From: Sue Howell <Sue.Howell@arun.gov.uk>
Sent: 12 October 2020 13:55
To: Planning.Responses <Planning.Responses@arun.gov.uk>
Cc: Simon Davis <Simon.Davis@arun.gov.uk>
Subject: RE: Planning Consultation on: Y/72/20/RES

Application ref: Y/72/20/RES

Description: Approval of reserved matters following outline approval Y/44/17/OUT for the erection of 70 No. dwellings in the Arun District Council Greenspace Conservation Area & affects the setting of Listed Buildings.

Location: Land at Stakers Farm North End Road Yapton

PROJECT NUMBER:	PLOT DATE:
DD427	28.07.2020
DRAWING SCALE:	APPROVED BY:
1:50	PD
PAPER SIZE:	DRAWN BY:
A1	JT
DRAWING TITLE	
Play Equipment Plan

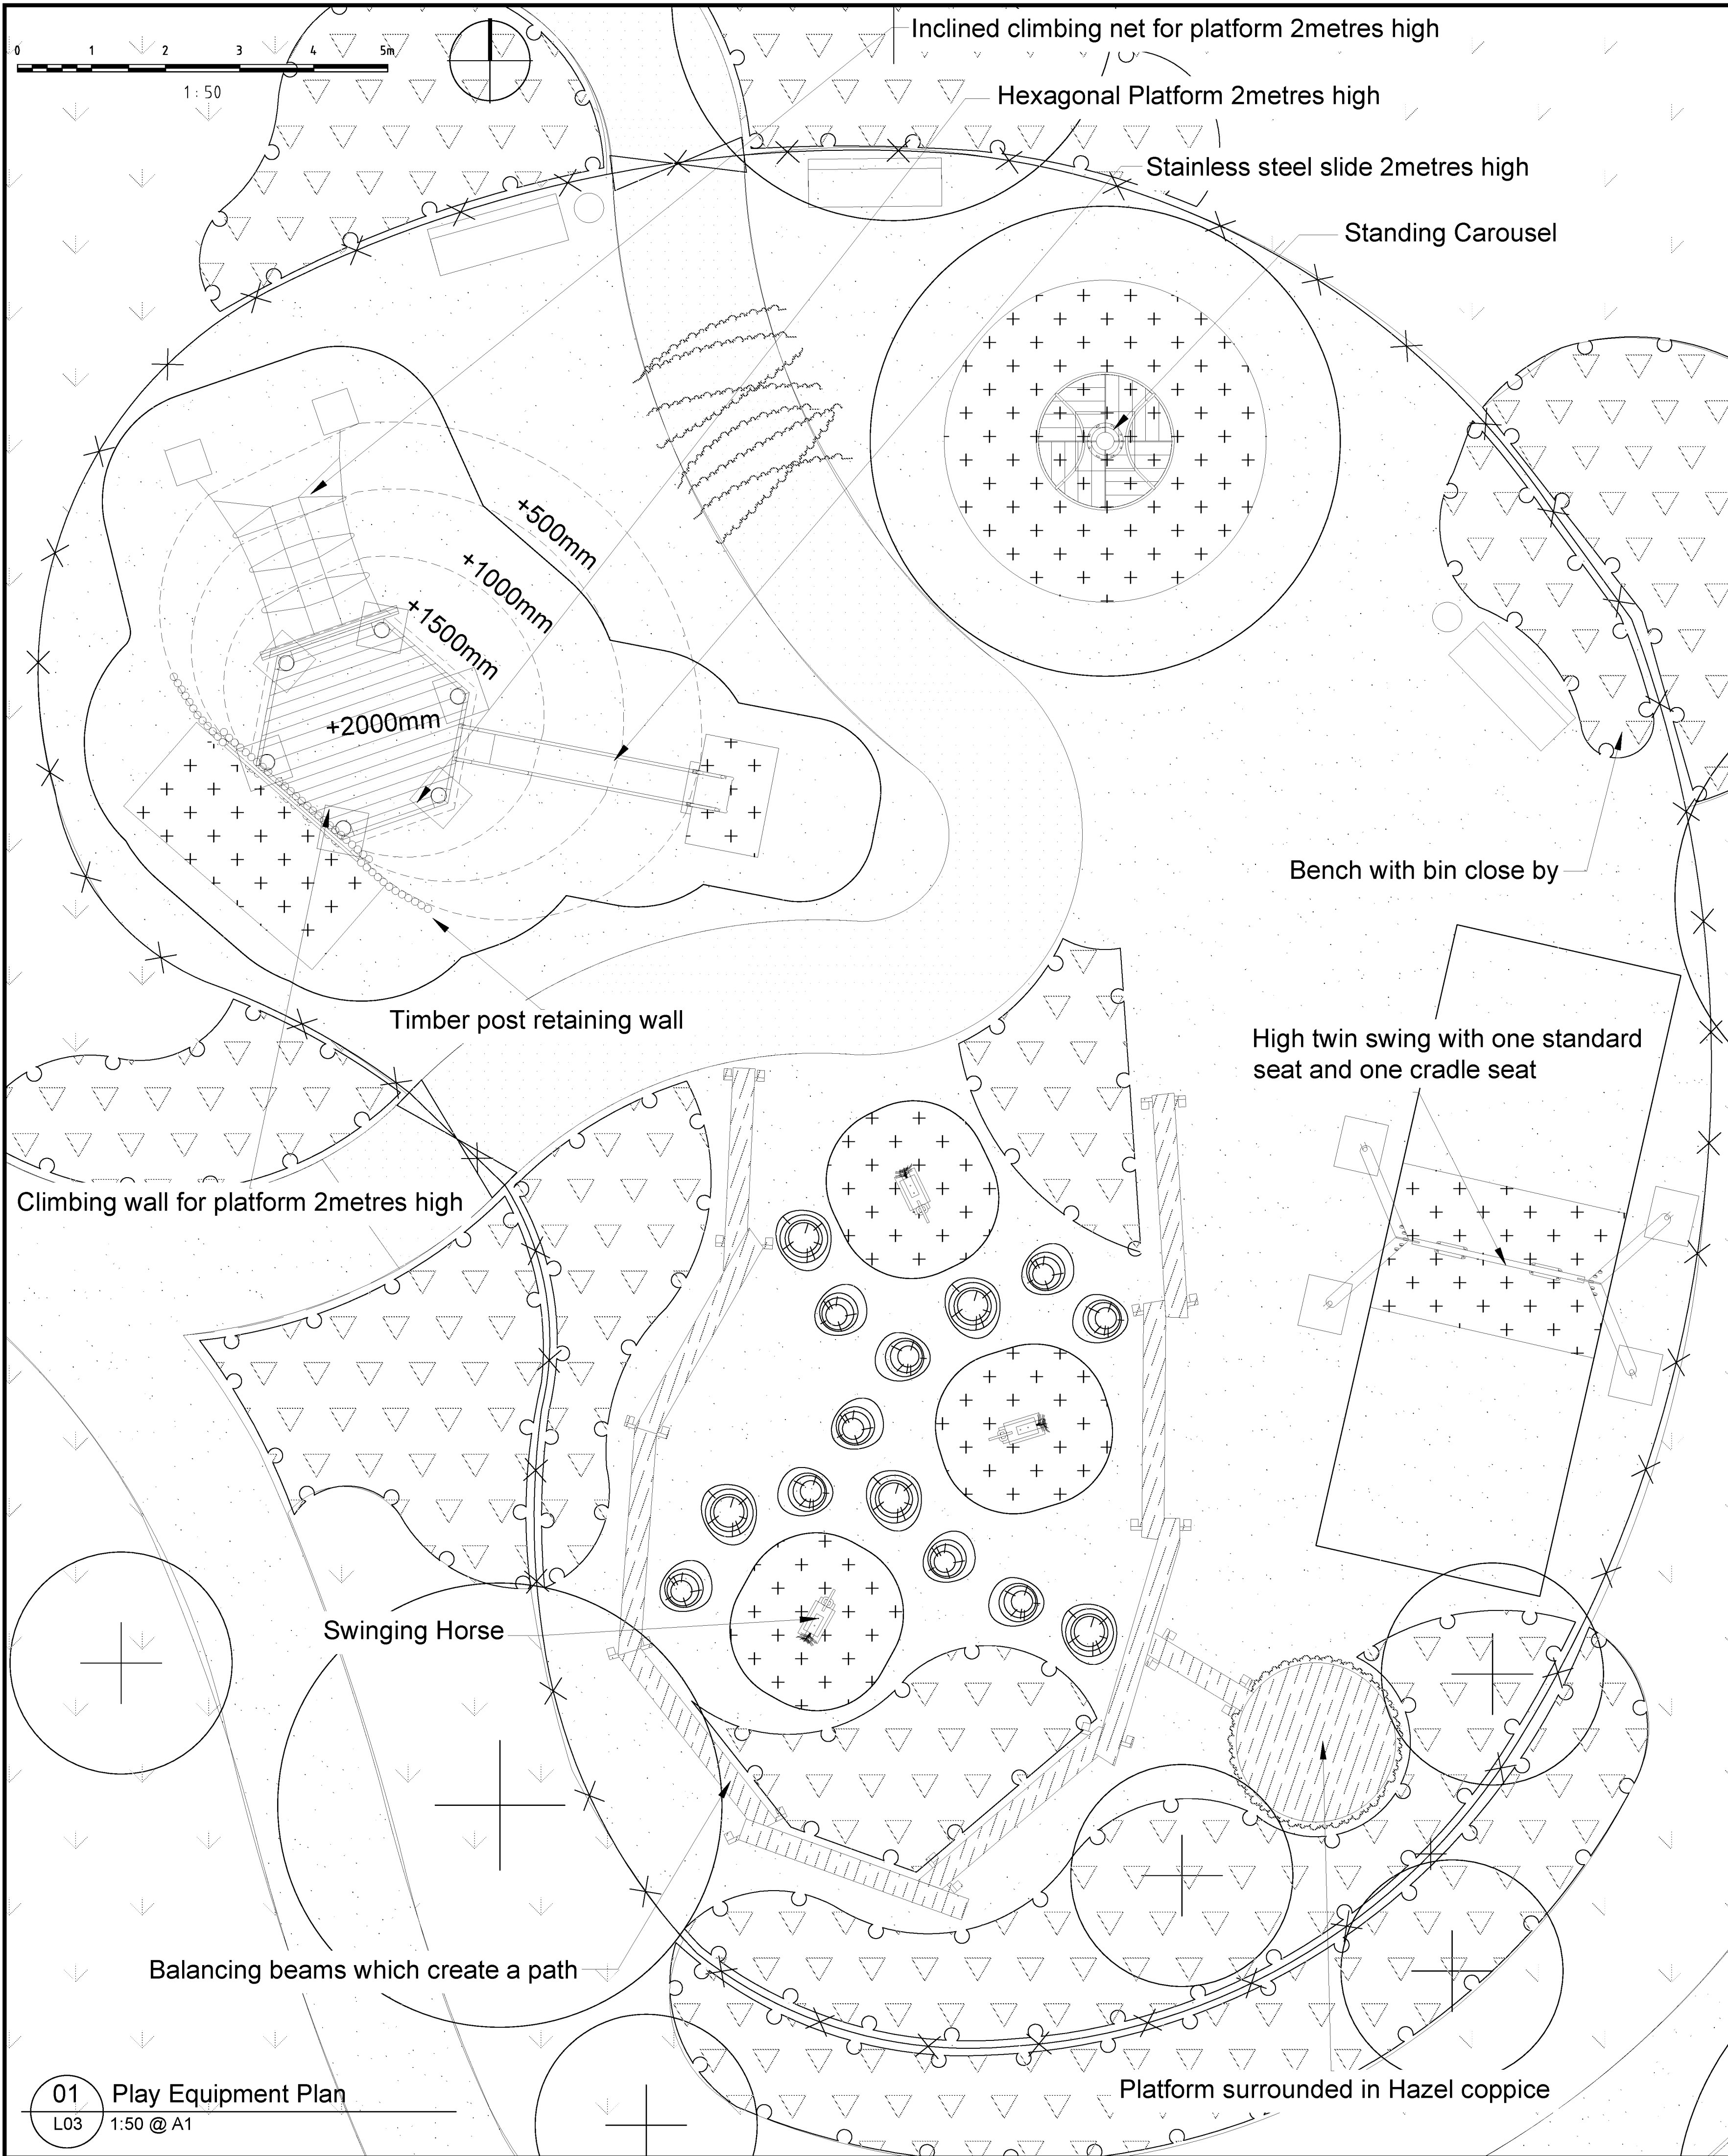
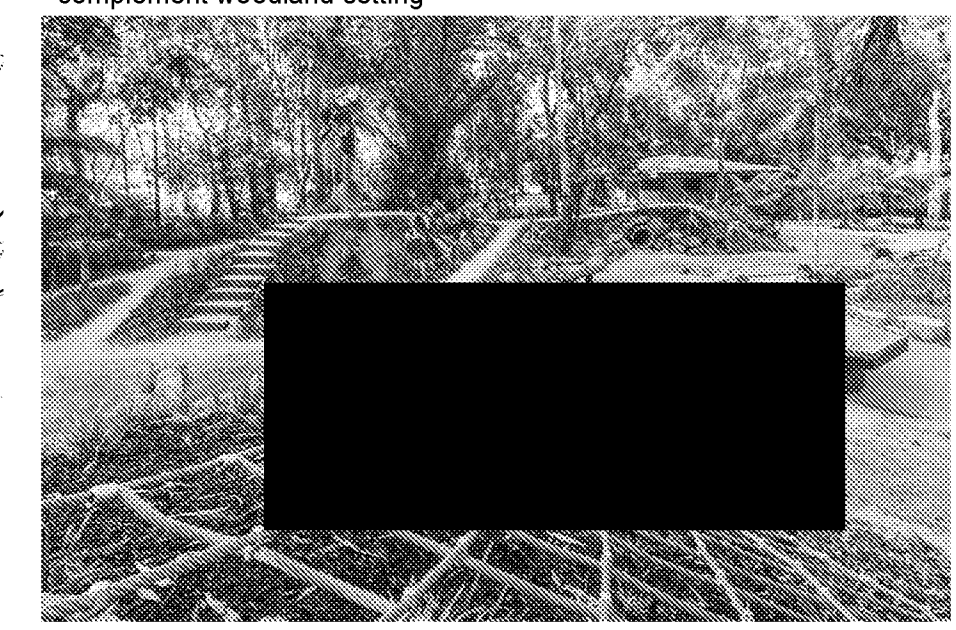
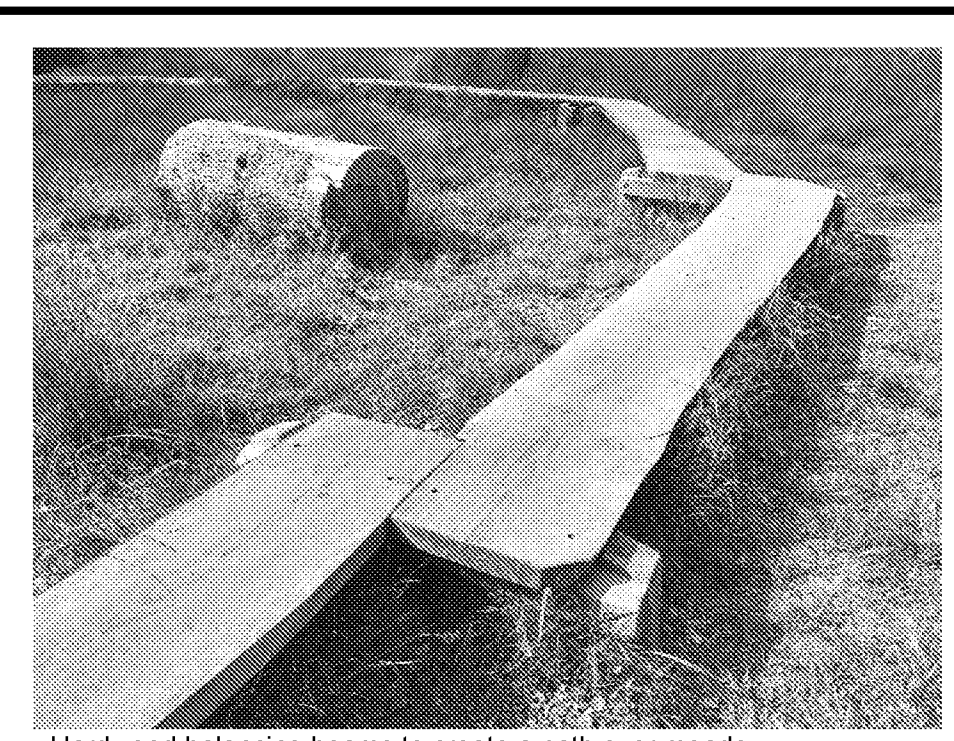
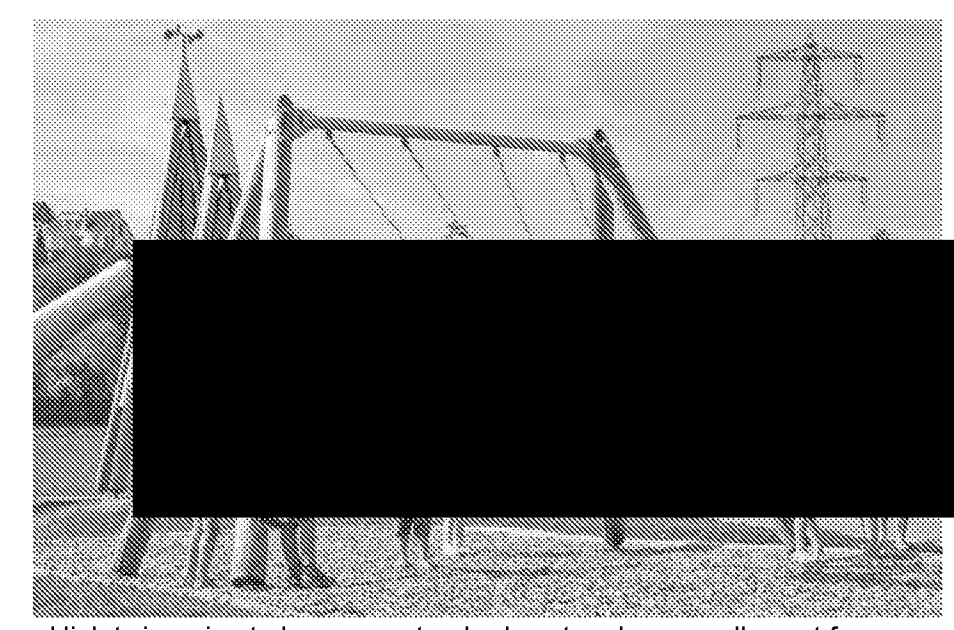
- Play area – The play area dwg Plan DD427 LO3 has proposed an imaginative and well thought out play offer LEAP in this development (this is in addition to the land gift to the school) The play offer experience is good with a good mix of equipment and material choice. I would highlight however that hoggin pathways, hardwood play chips and the inclusion of coppiced play features would not be supported if to be adopted by the LPA because of maintenance requirements and should it be proposed for handover to LPA they would need to be amended – If this play area is to be maintenance company maintained and therefore no forward LPA maintenance liability going forward then happy for these to remain.
